Subject: RE: WA/34/22/DOC - Condition 2

I am writing on behalf of David Easton for the above planning application relating to EV charging. Please could you respond and confirm the below points raised by Environmental Health:

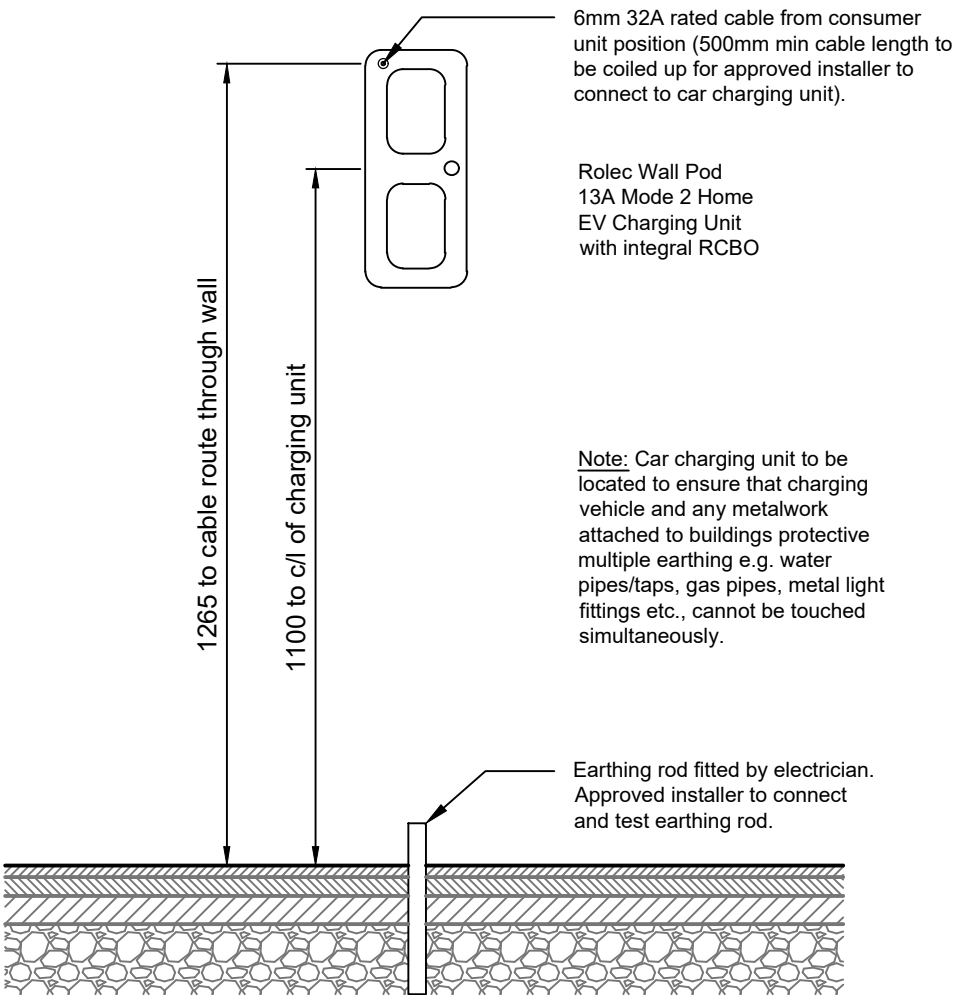
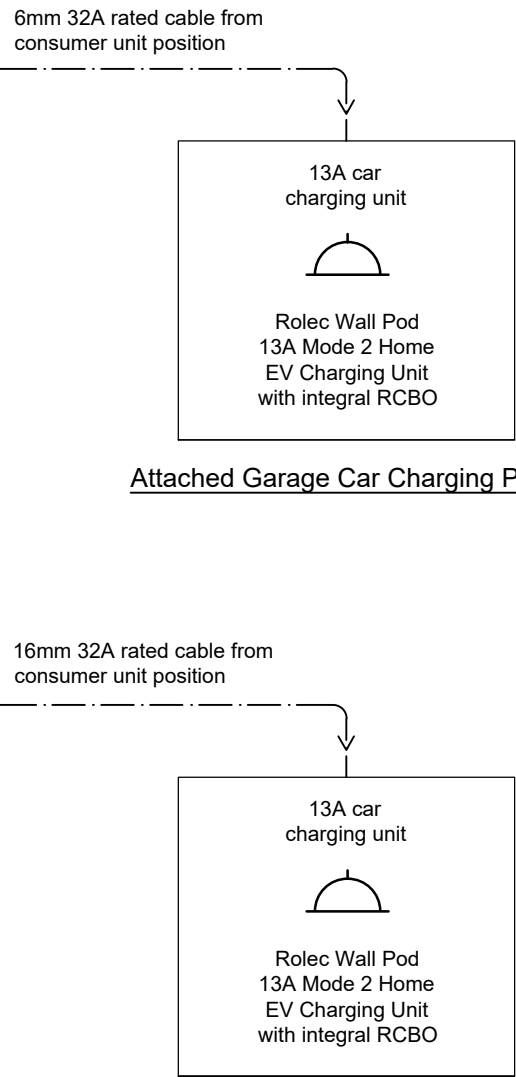
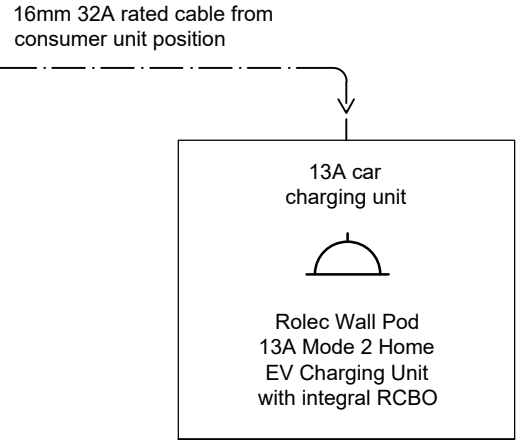
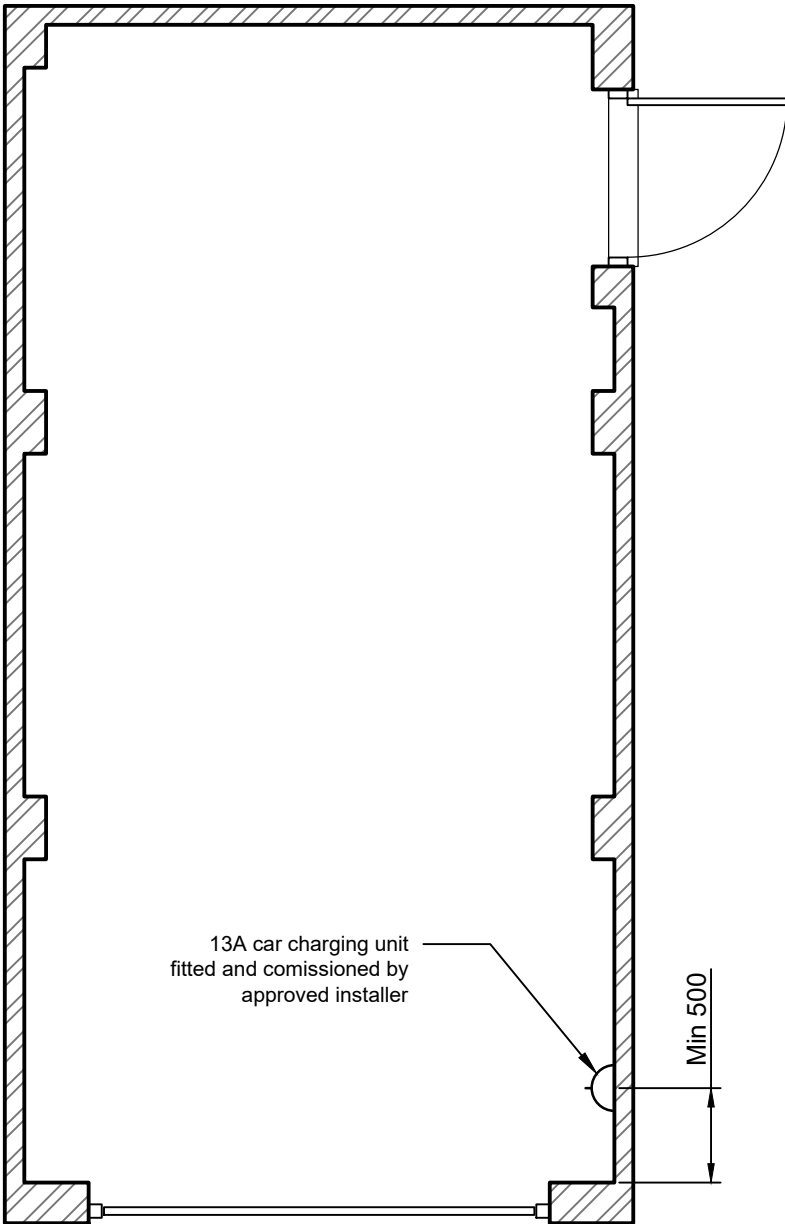
1. That 100% of the houses with a driveway or a garage have an active EV charging point.
2. That 30% of parking spaces for all other developments have an active EV charging point.

3. The specific numbers of parking spaces that 1 and 2 refer to (i.e. number of dwellings)
4. That the proposed EV charging points meet all the following requirements:

- a. Be designed and installed as described in BS EN 61851.
 - b. Have a minimum nominal rated output of 7kW.
 - c. Be fitted with a universal socket (also known as an untethered electric vehicle charge point). Alternatively, in exceptional circumstances, such as for a self-build property, if the vehicle requirements are already known, a tethered electric vehicle charge point may be acceptable.

- d. Be fitted with an indicator to show the equipment's charging status that uses lights, or a visual display.
 - e. Be a minimum of a Mode 3 specialised system for electric vehicle charging running from a dedicated circuit, or equivalent, as defined in BS EN IEC 61851-1.

- f. The requirements of BS 7671.
 - g. The requirements in the IET's Code of Practice: Electric Vehicle Charging Equipment Installation.

No further comments. Environmental Health is happy for this condition to be discharged.

1. Correct.
2. Correct.
3. 1) 296 houses – 279 possible, 2) 104 flats – 39 EV spaces as below:
 - Block B – 12 flats – 4 EV spaces
 - Block C – 18 flats – 6 EV spaces
 - Block D – 12 flats – 5 EV spaces
 - Block E – 8 flats – 4 EV spaces
 - Block F – 12 flats – 5 EV spaces
 - Block G – 12 flats – 4 EV spaces
 - Block H – 24 flats – 8 EV spaces
 - Block J – 6 flats – 3 EV spaces
4. Correct.
